**Our Ref: FP/153/12/
Your Ref:**

Application for Planning Permission for Works or Extension to a Dwelling

Development Front and rear extensions
Location 43 Downview Road Felpham

Project: Proposed alterations; Little Thatch, Downview Road, Felpham PO22 8HH	
Drawing: Plans as proposed	
For: Mr. R. Taft	
Drawn: PKS	Date: July 2012
Scales: 1:100	No: 960/01/04
To scale when printed on A3

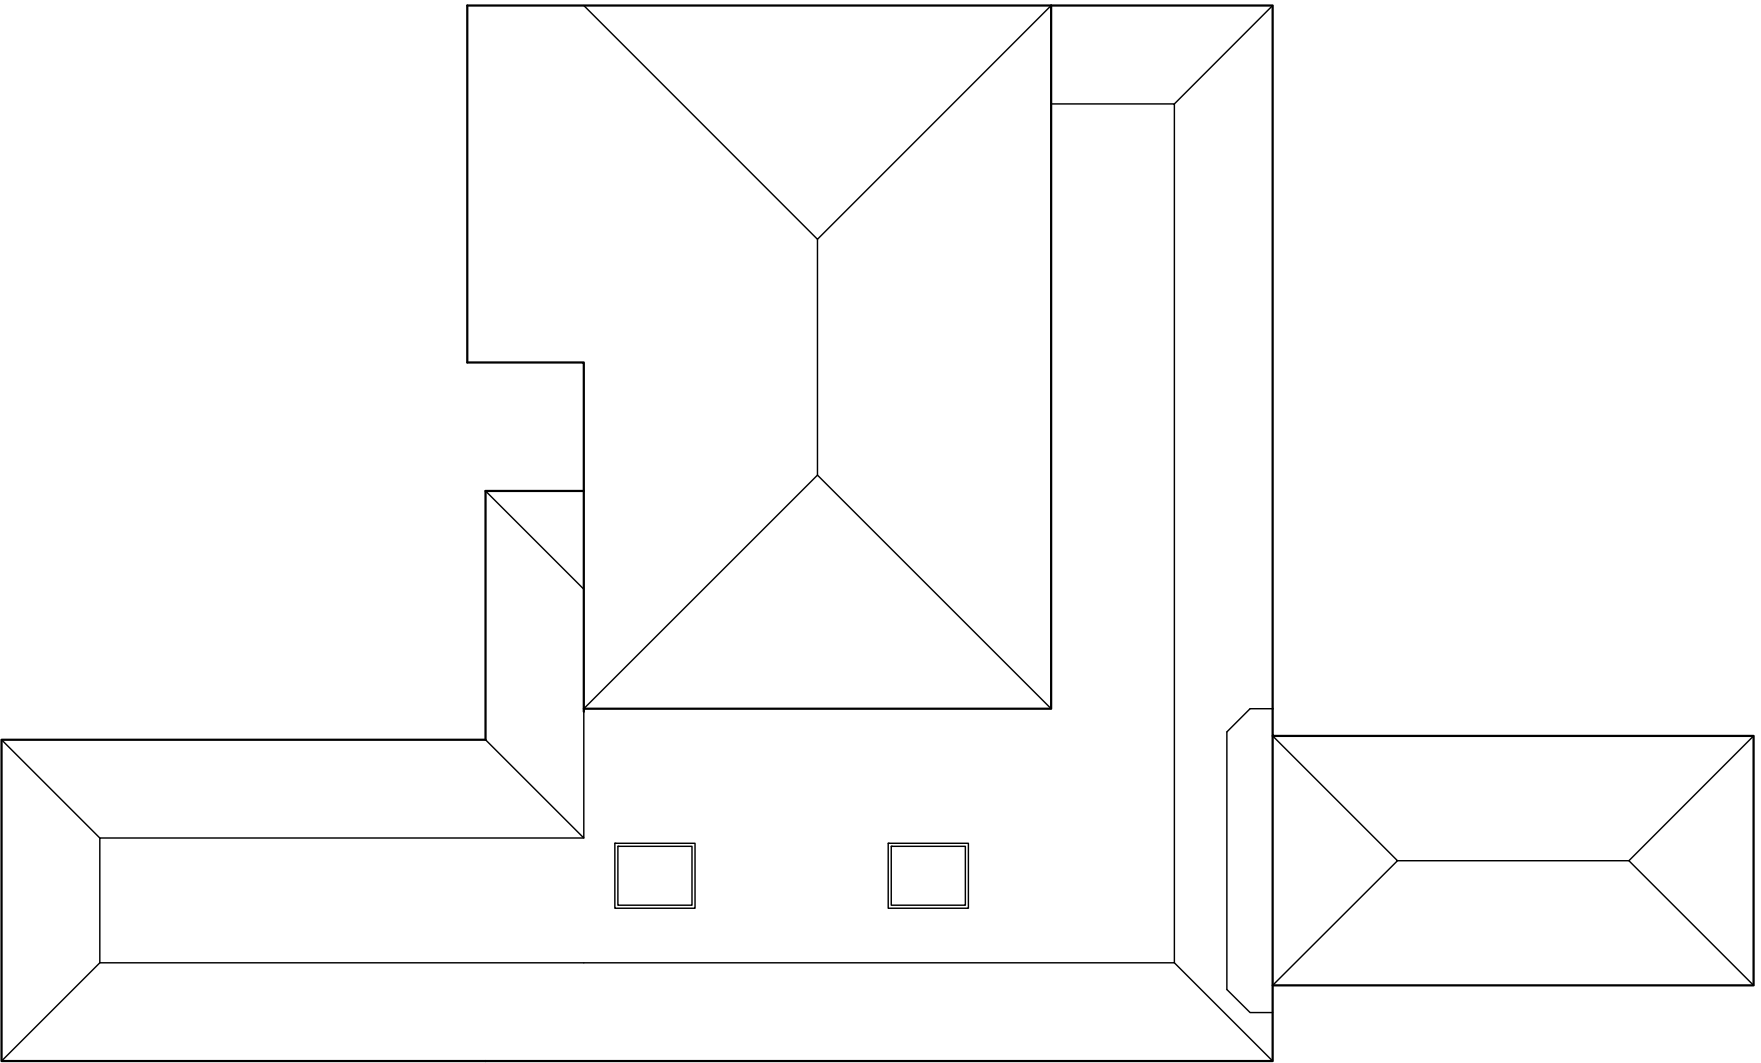
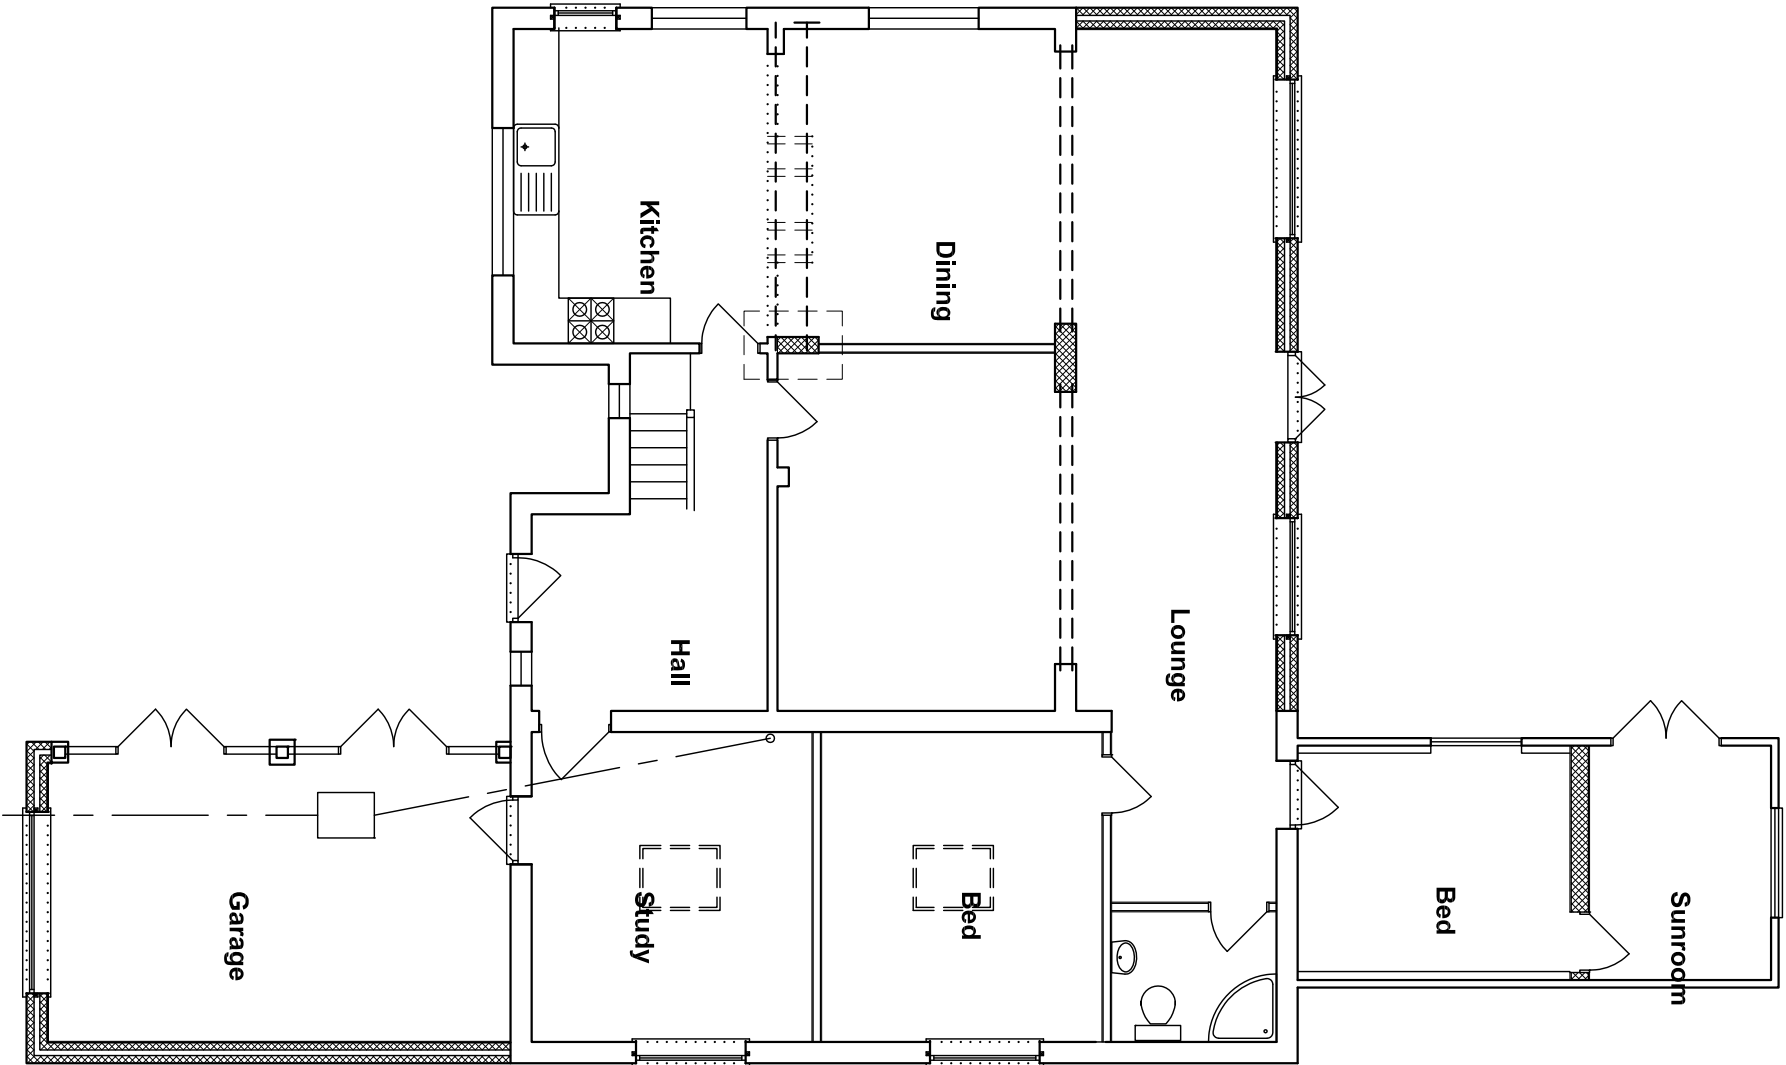
The proposed South elevation and South floor plan do not accord. Please amend accordingly. ✓
